Applicant's comments on Deadline 5 Submissions

PINS Reference Number: EN010069

Deadline 6 – 18 March 2019

- 1.1.1 The Applicant, Abergelli Power Limited, is applying to the Secretary of State (SoS) under the Planning Act 2008 (PA 2008) for development consent to construct, operate and maintain an Open Cycle Gas Turbine (OCGT) gas fired peaking power generating station, fuelled by natural gas with a rated electrical output of up to 299 Megawatts (MW) (the Abergelli Power Project).

Illustrative Elevation of Road Structure Over Utilities

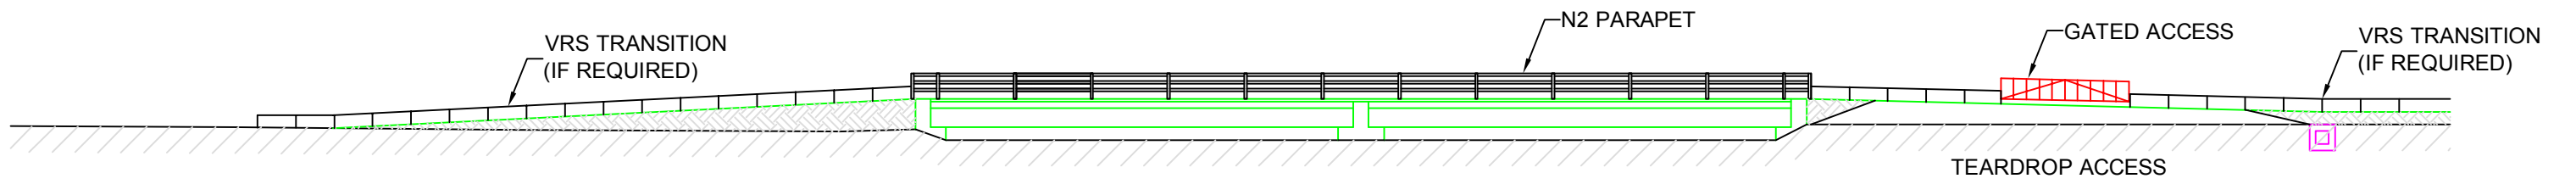
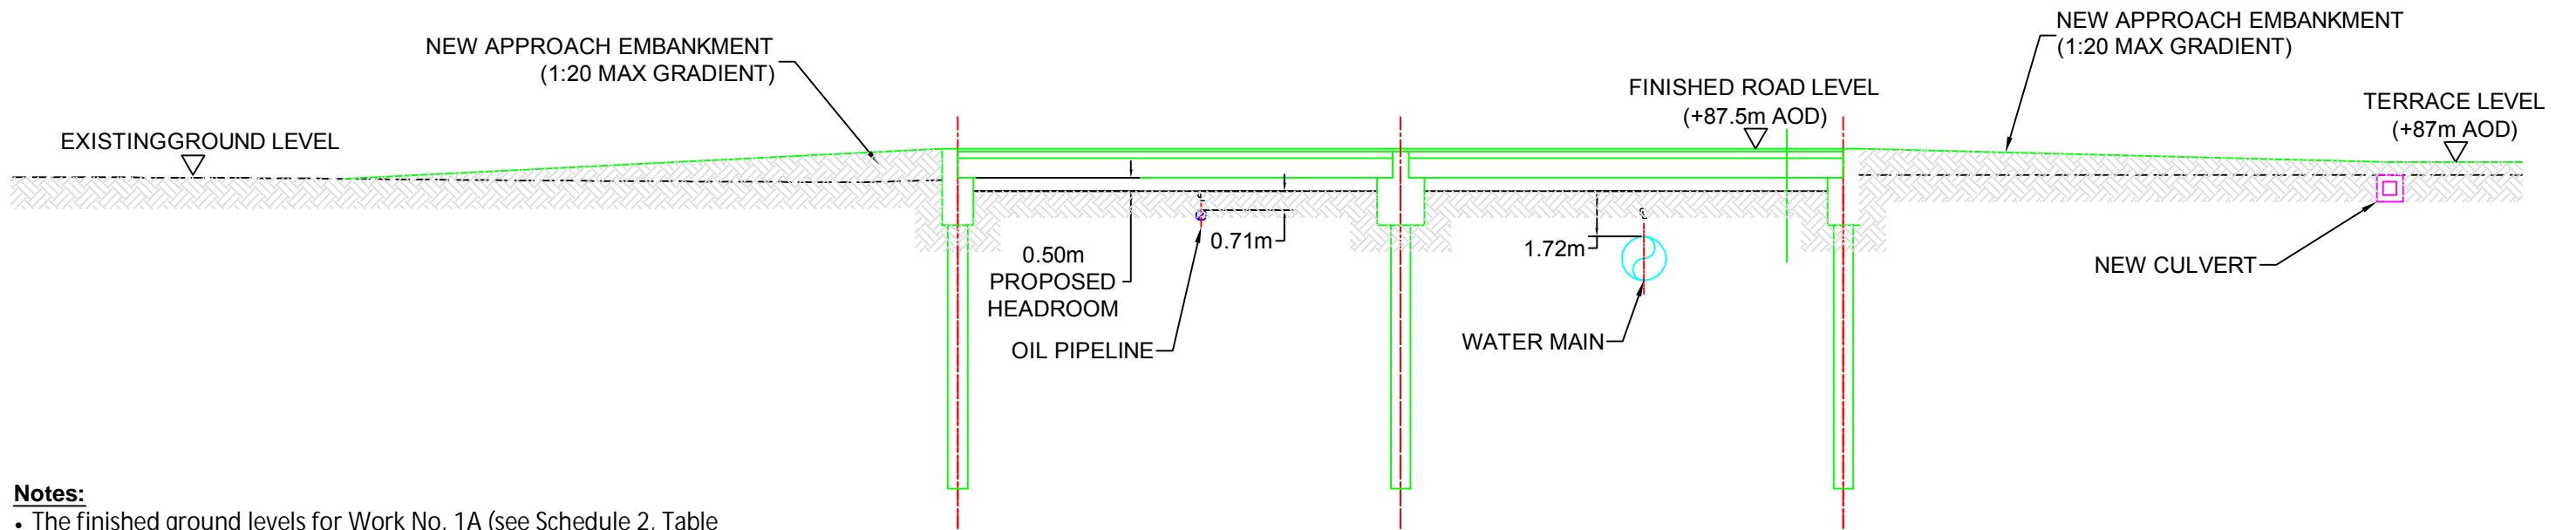
Table 3 – Parameters of Road Structure over Water Main

- 2.3.1 CCS have queried whether the height of the safety barrier (1.2 m) described in Schedule 2 Table 3 of the DCO is included in the maximum height of the road structure (5 m). To clarify, the height of the safety barrier is not included in the 5 m maximum height, rather 1.2 m is the maximum height of the safety barrier, measured above the top of the road structure.
- 2.3.2 Grid lines have been added to Schedule 2 Table 3 of the DCO submitted for Deadline 6 so that the presentation of the parameters for the crossing structure and its safety barrier is clearer.
- 2.3.3 Work No. 2 has also been updated to include express reference to the structure over the water main and decommissioned oil pipeline that will be constructed as part of the Access Road.
